Falcon Storage Expansion

Transportation Memorandum

Please add PCD File No. MS232
& PPR2232

RE: Falcon Storage Expansion
Transportation Memorandum
El Paso County, CO
LSC #S214430

Figure 2 Site Plan

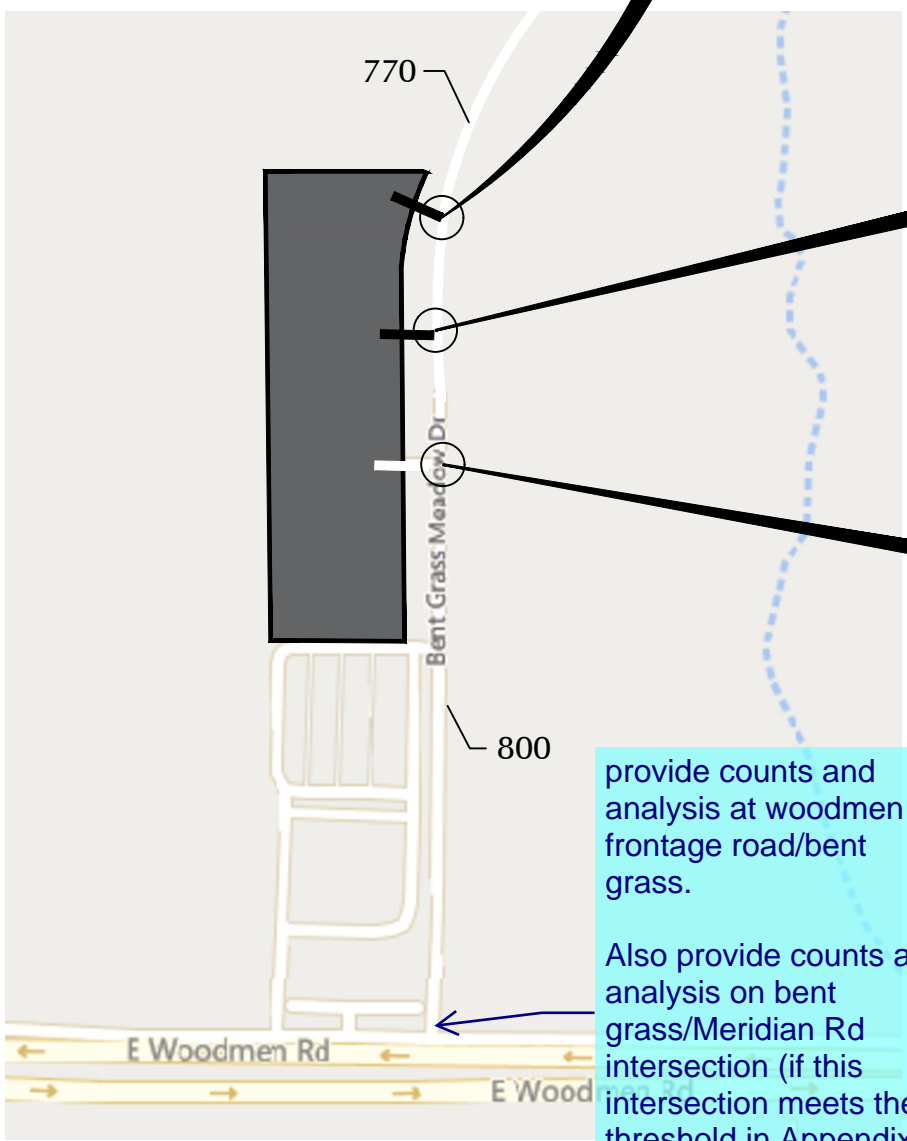
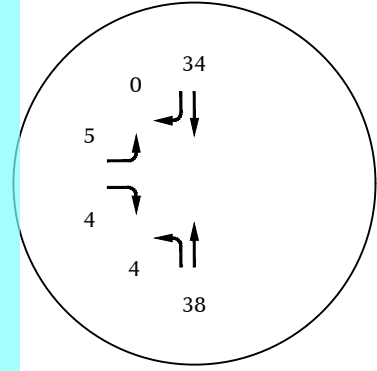
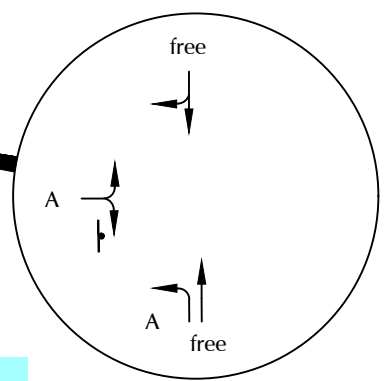
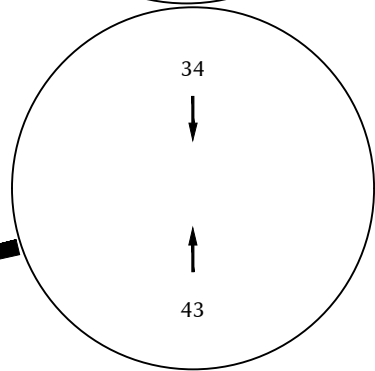
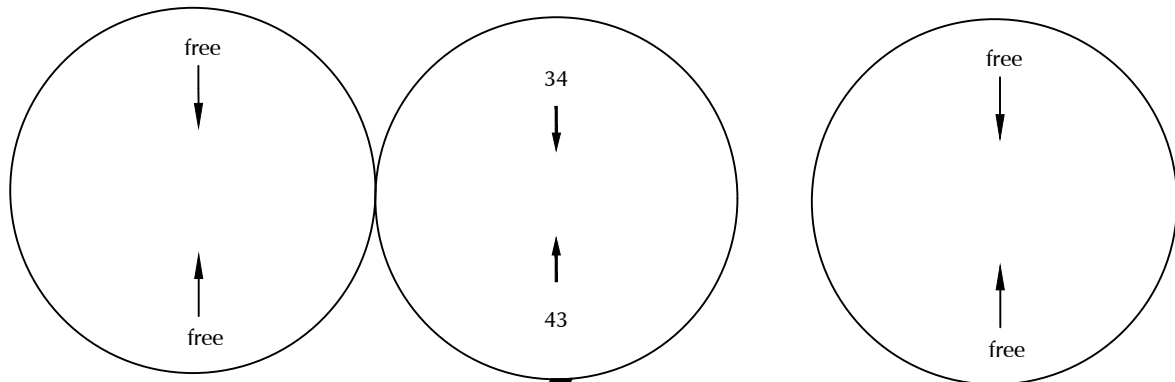
only a single access is proposed on the most recent site development plan. Revise accordingly.

revise accordingly as a single new access point is provided. Please update throughout the narrative.

update accordingly per previous comments.
